# ENG-SF20028-R1-FGP.pdf Markup Summary

**Subject:** EPC ENG Review  
**Page Index:** 1  
**Date:** 12/30/2020 12:28:40 PM  
**Author:** dsdrice  
**Color:** ■  
**Layer:**  
**Space:**  
**Page Label:** [1] 1 2514901CV01 - CV01

URBAN COLLECTION AT PALMER VILLAGE	SWALE CROSS SECTIONS	GEC PLANS
SHEET 3 OF 10	JOB NO. 25149.01

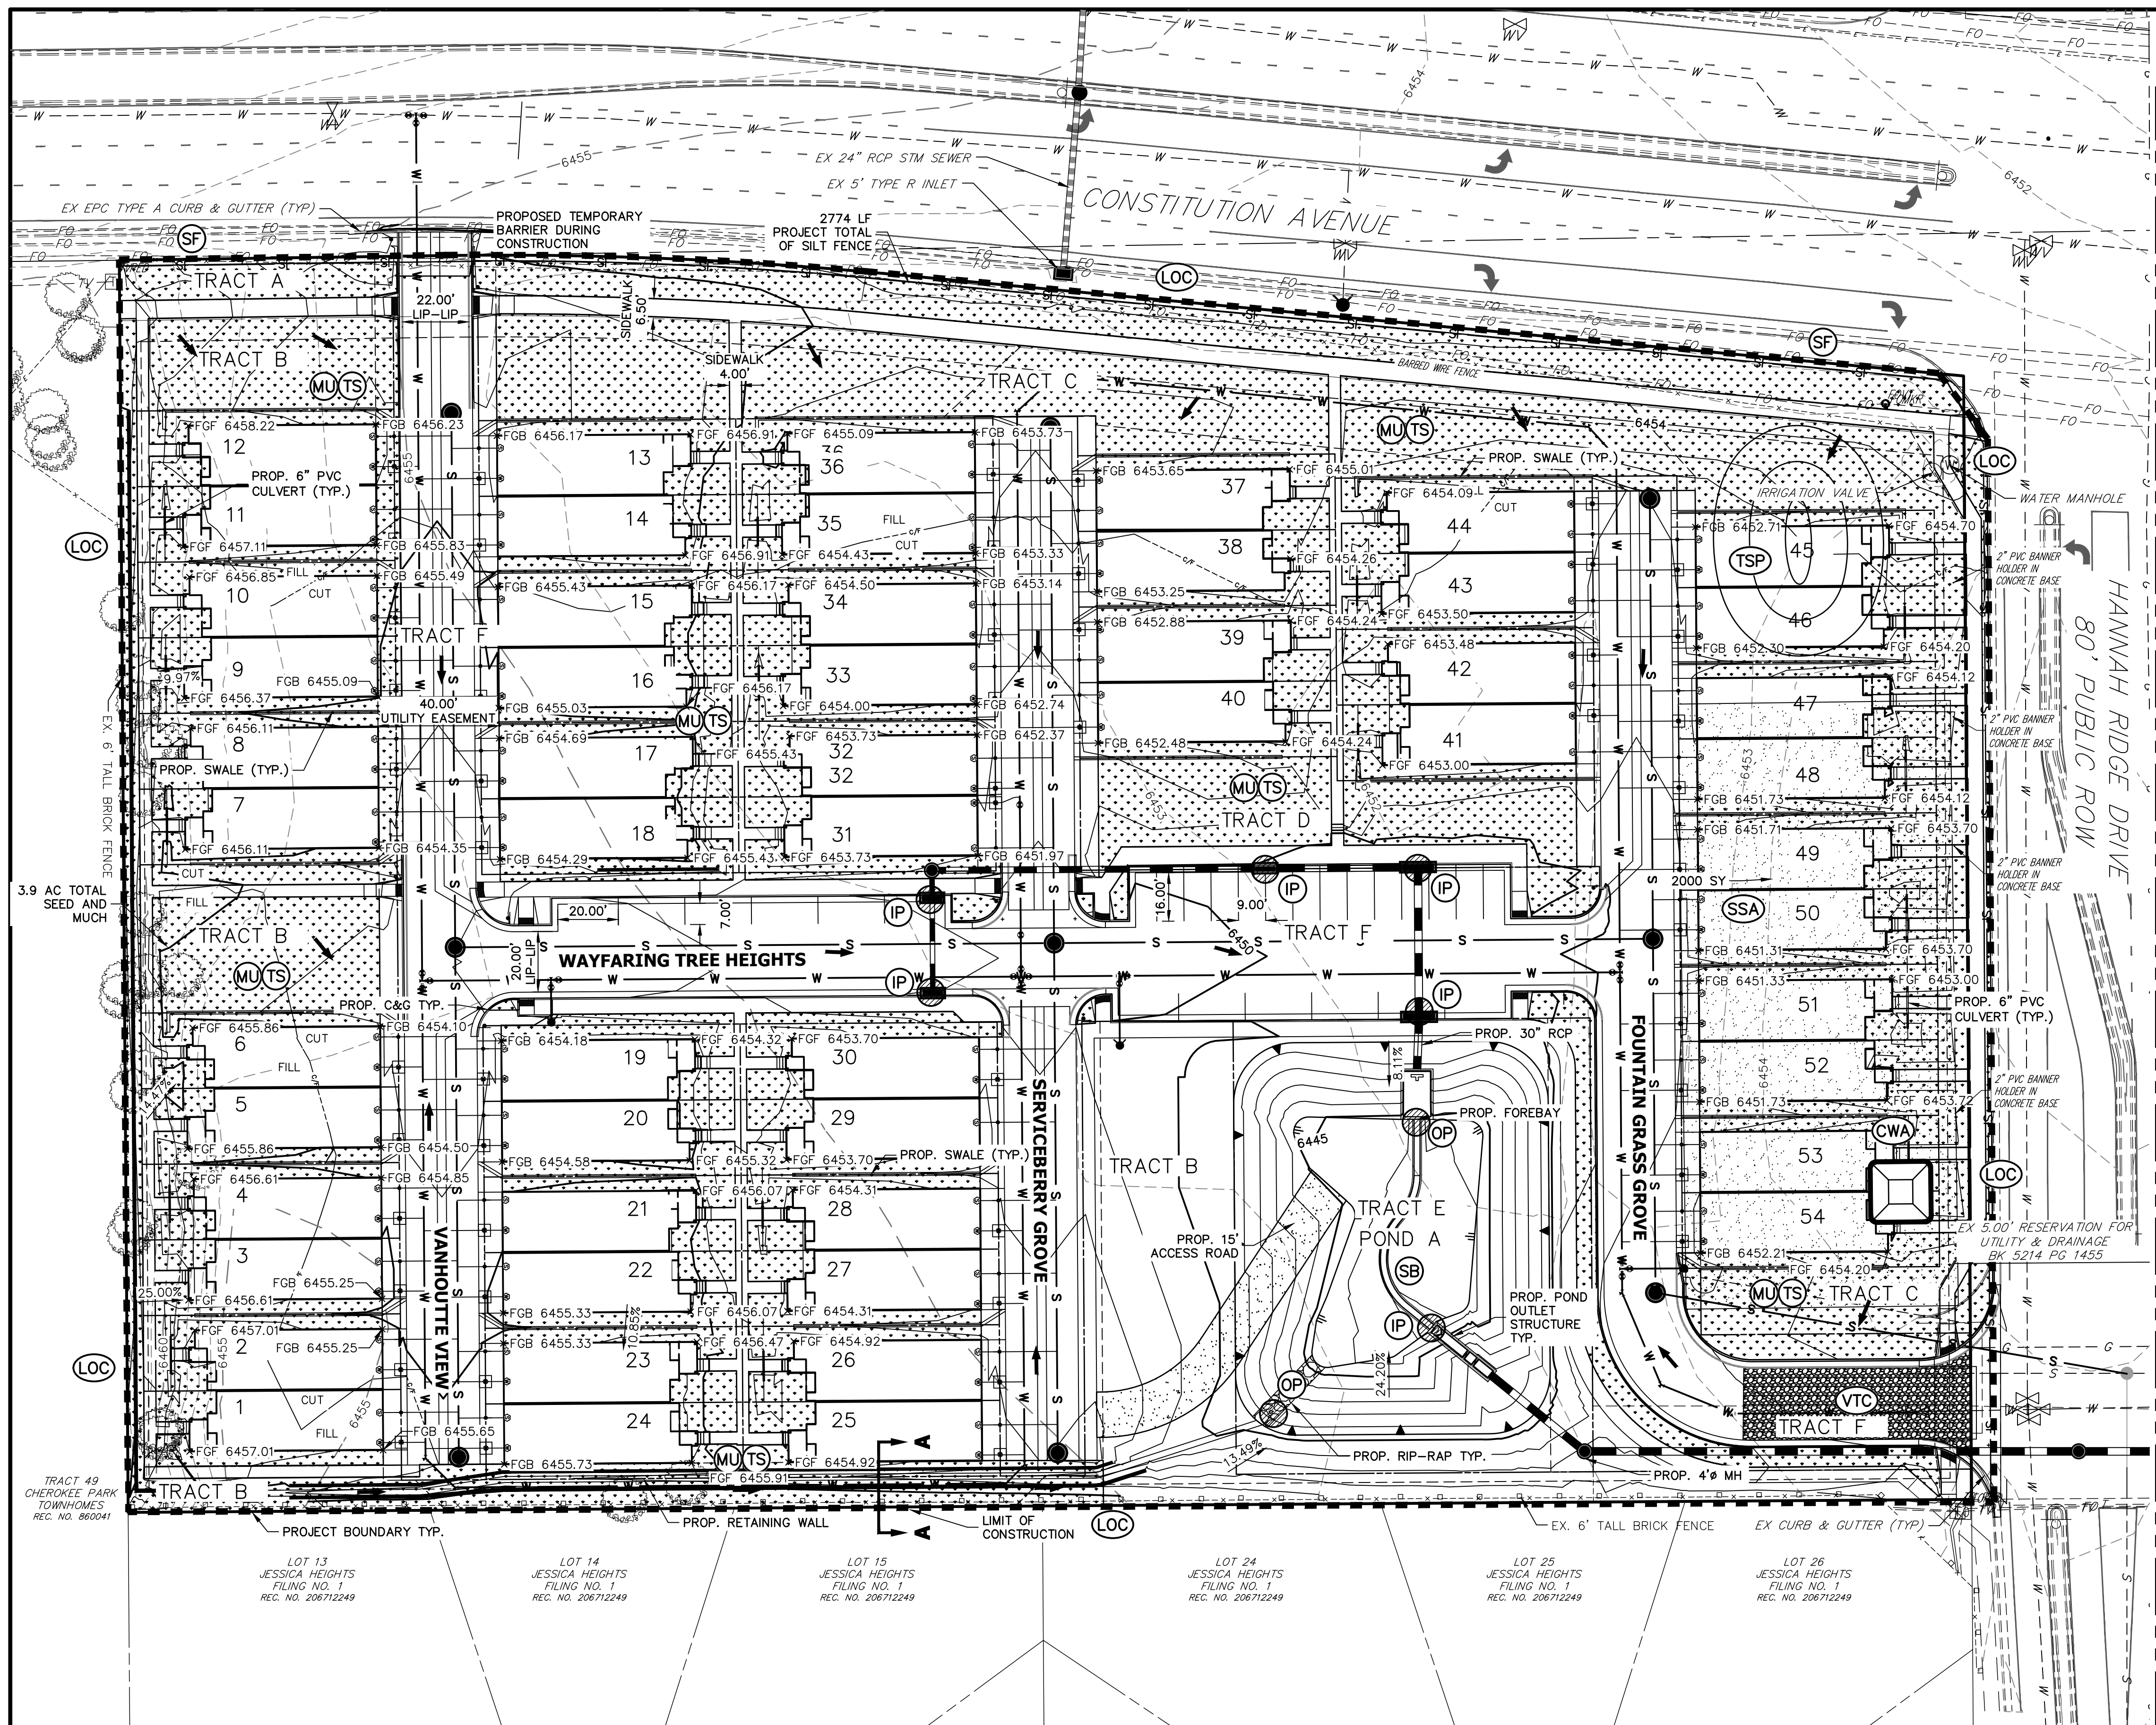
Provide cross-sections of swales.

Provide cross-sections of swales.

SHEET 4 OF 10
 JOB NO. 25149.01

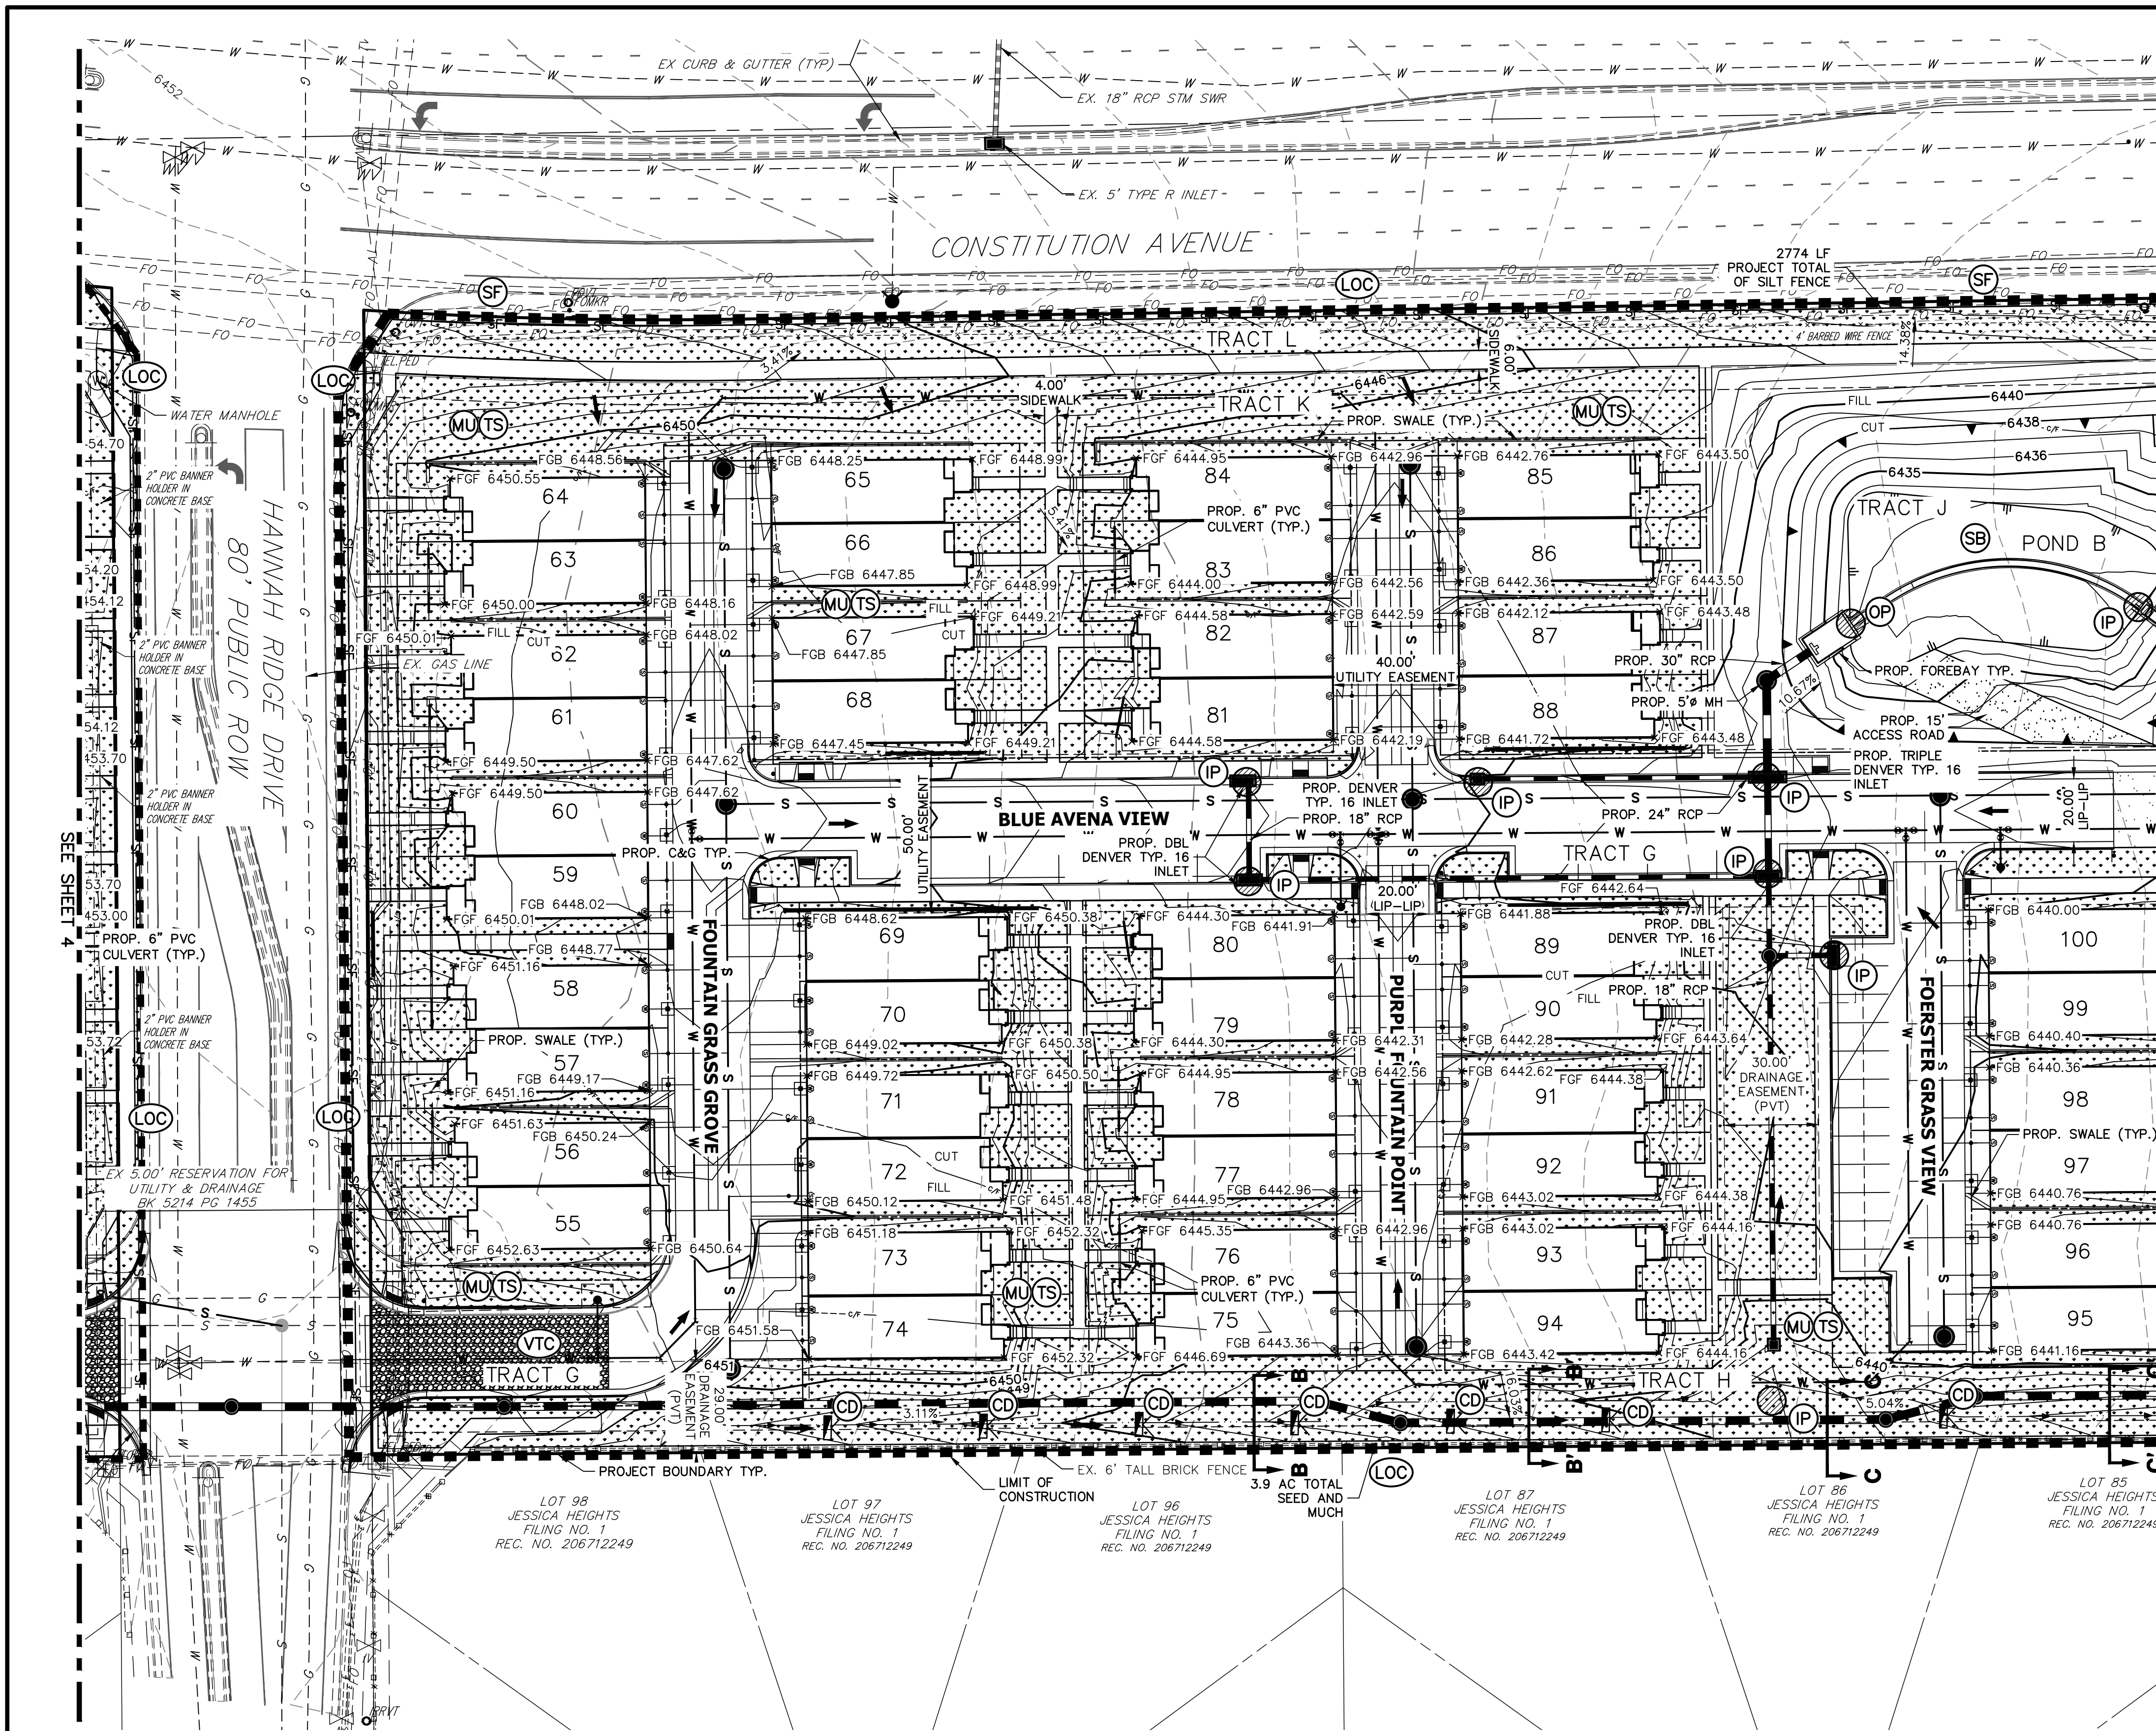
Handrail will be required.

SHEET 6 OF 10
 JOB NO. 25149.01

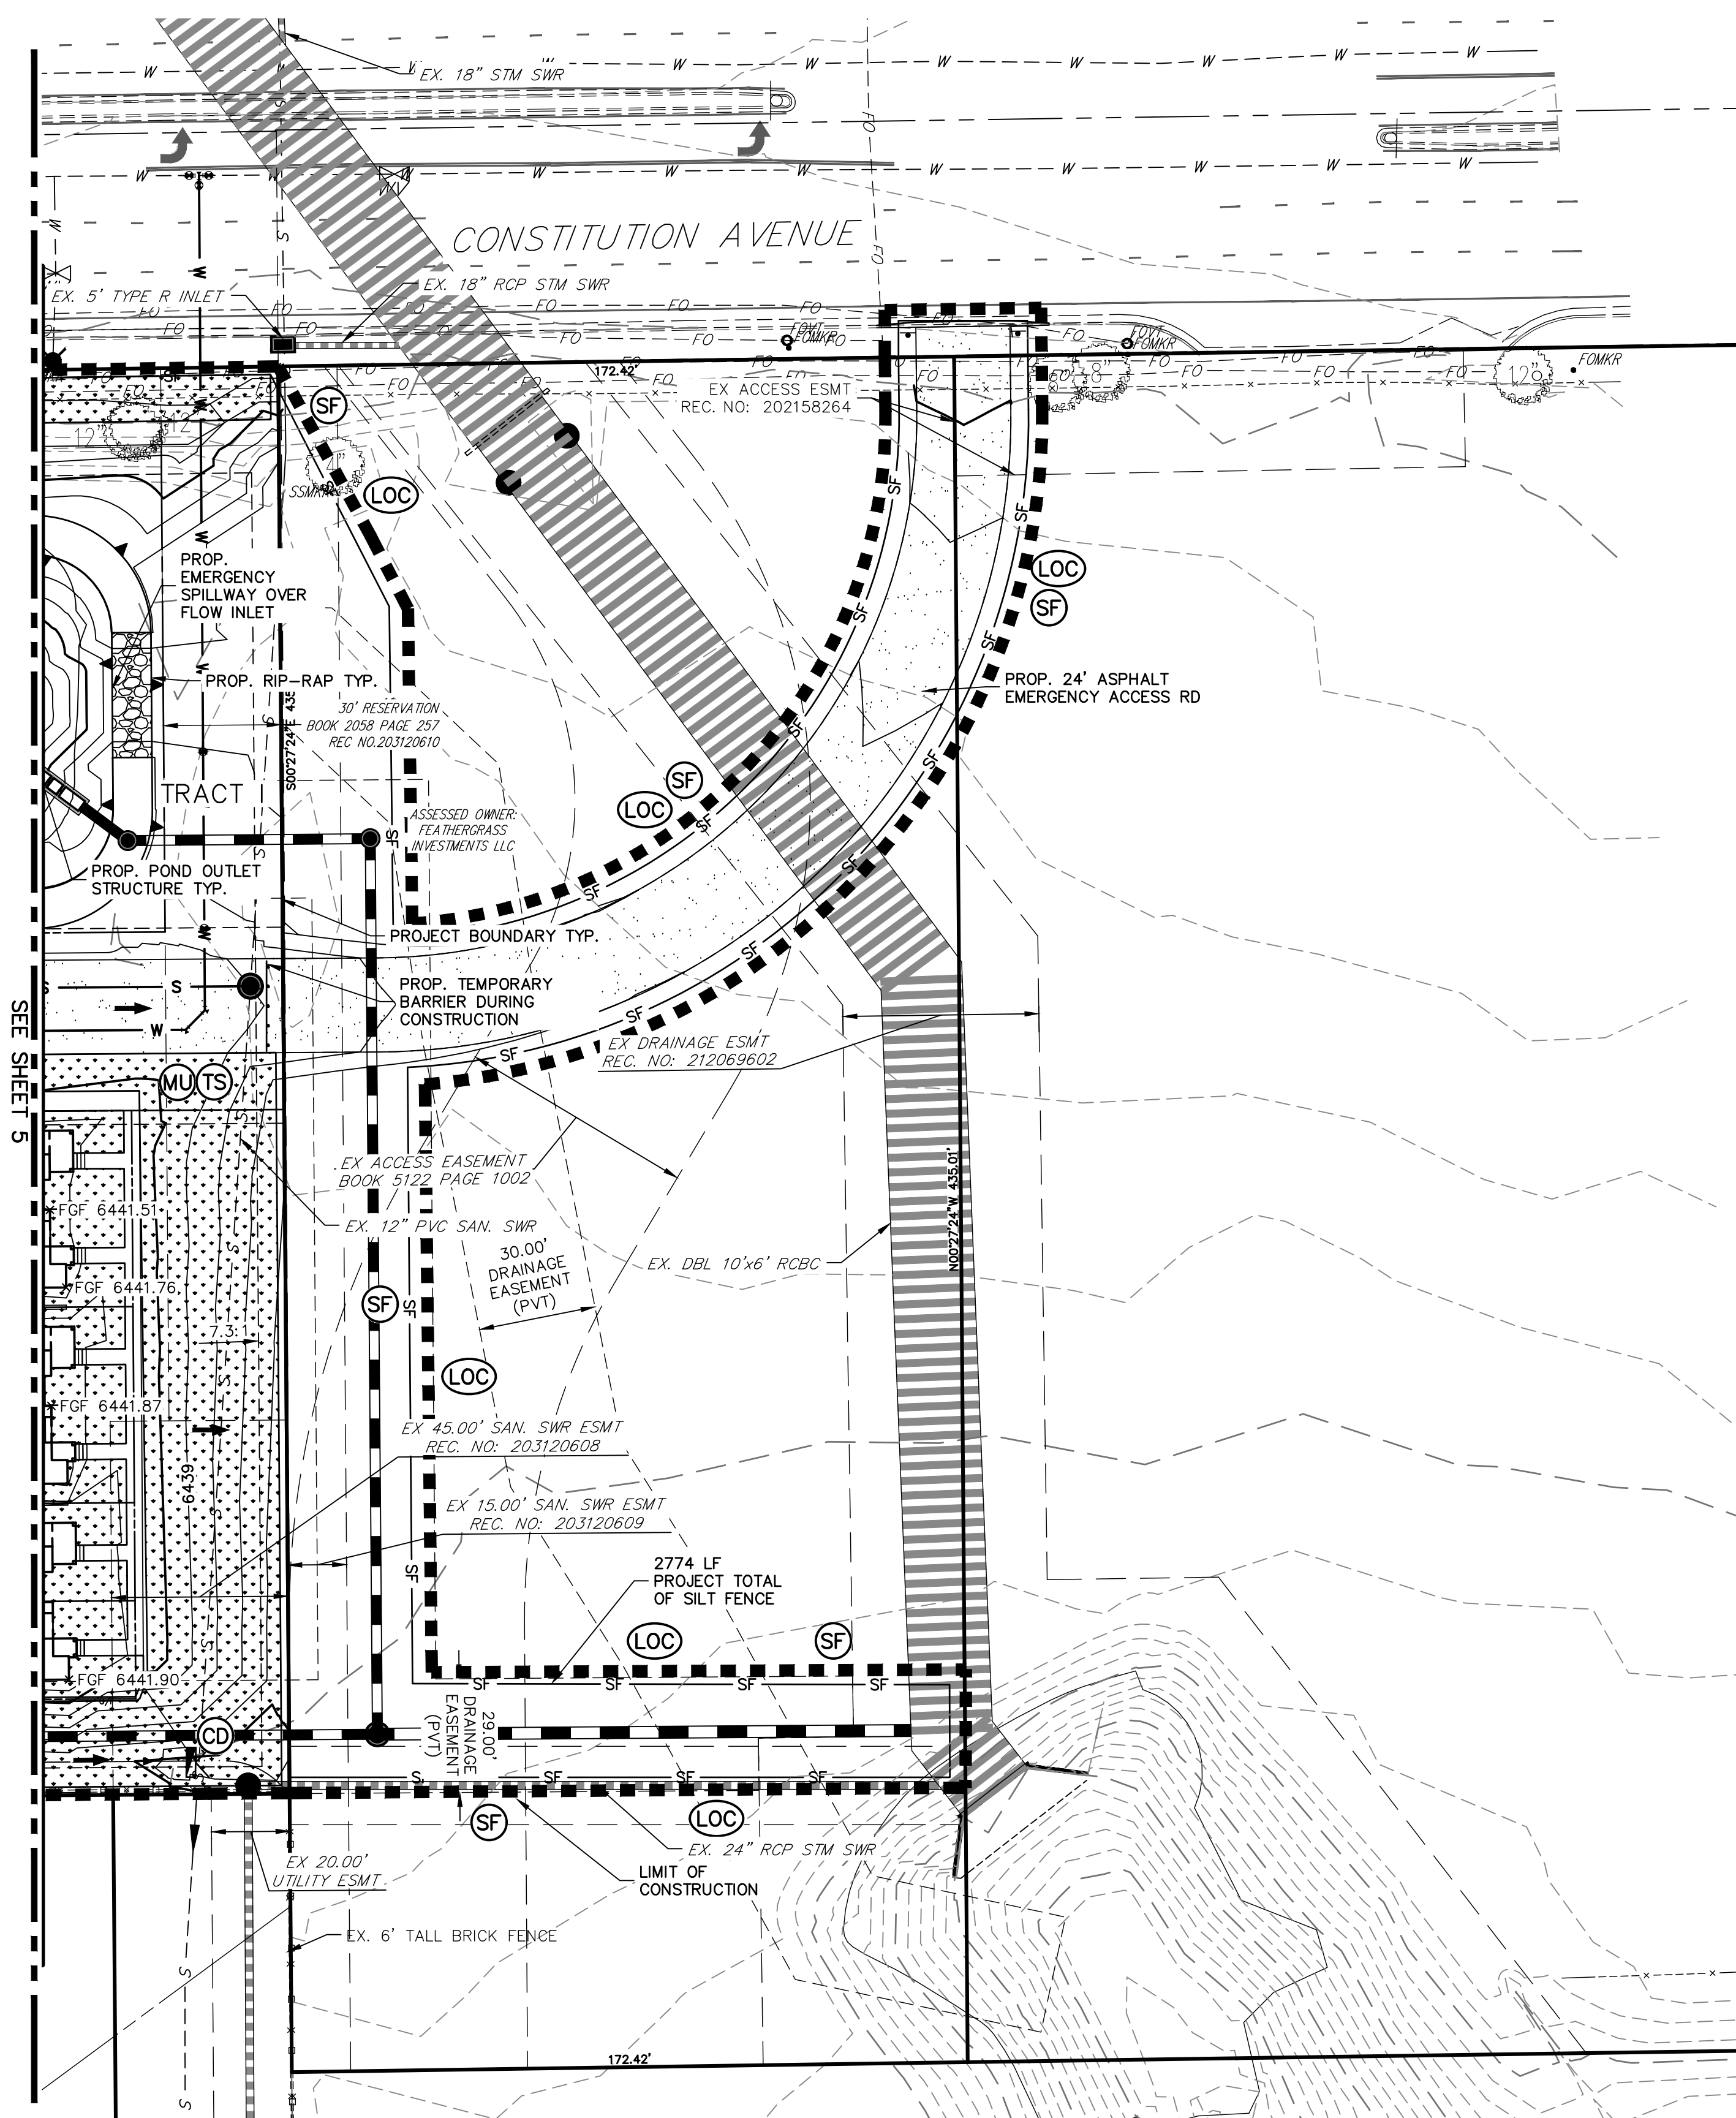
Label high point . Verify maximum WQCV capture area.
